PLANNING AMENDMENT

Application no: H22-0102-10

Description: Revised details and design of proposed wall (Condition 5 of H22-0852-09)

Amendment: Ground cover planting omitted from verge
(dwg. nos. 09/012/01B and JAN10/MD/09/012/02)

PROPOSED 1.5m RANTAGE WALK @ 523 BRIDGE, WESTON HILLS. FOR MR & MRS P. ISSITT. JAN 10 / MD / 09/012/02

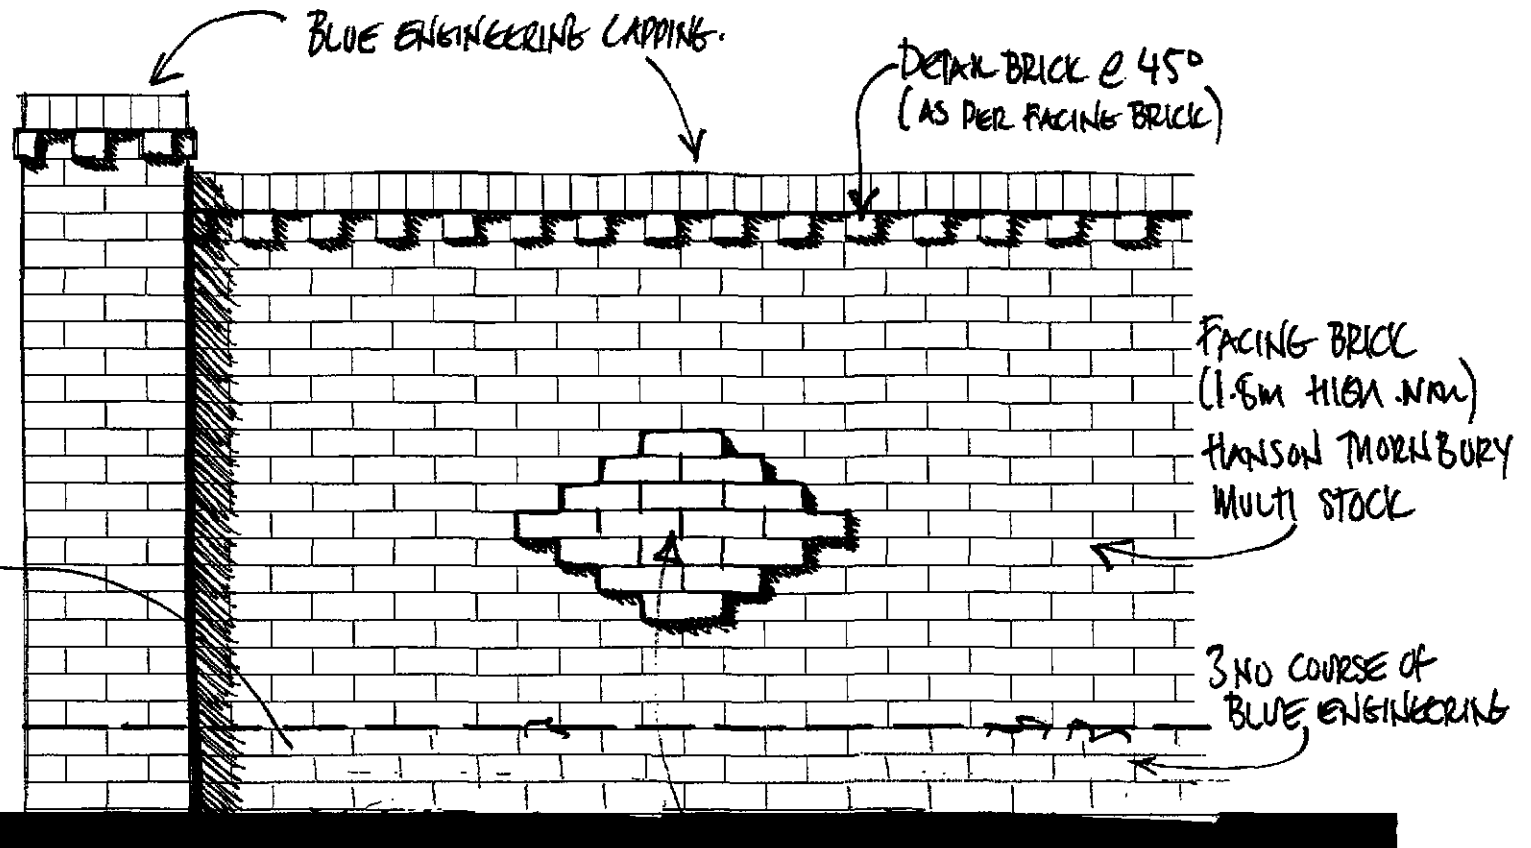
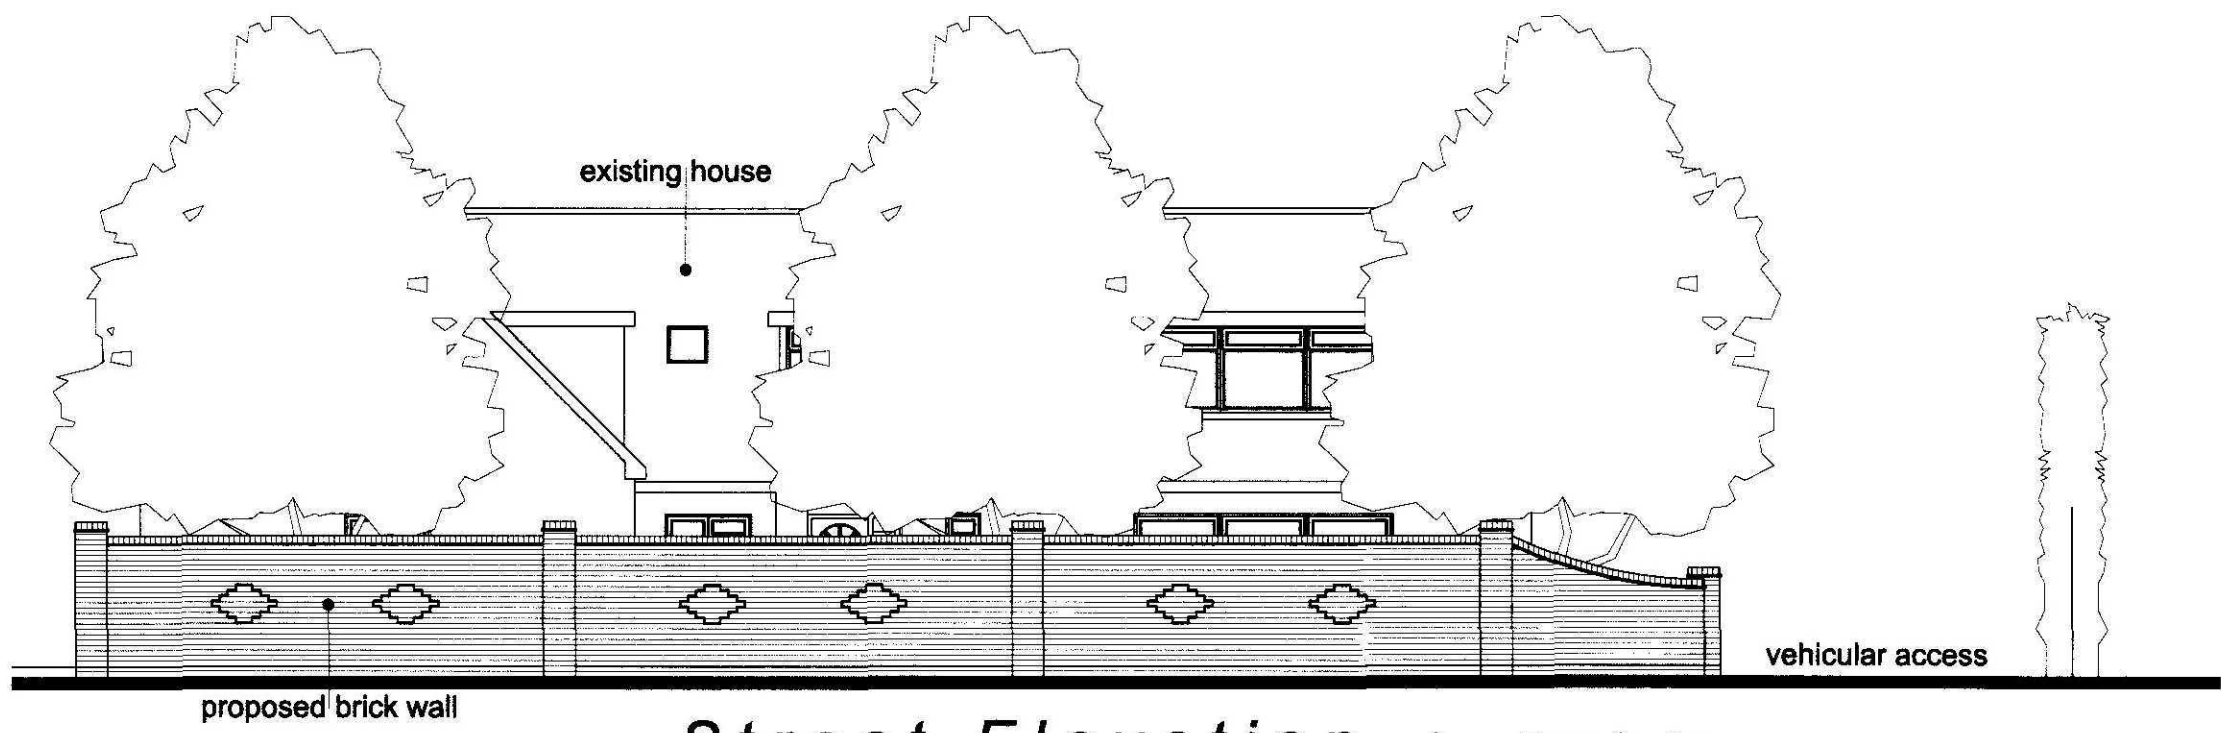
Dear Tracey,
Please find attached amended details, as requested. (ground cover planting omitted from verge)
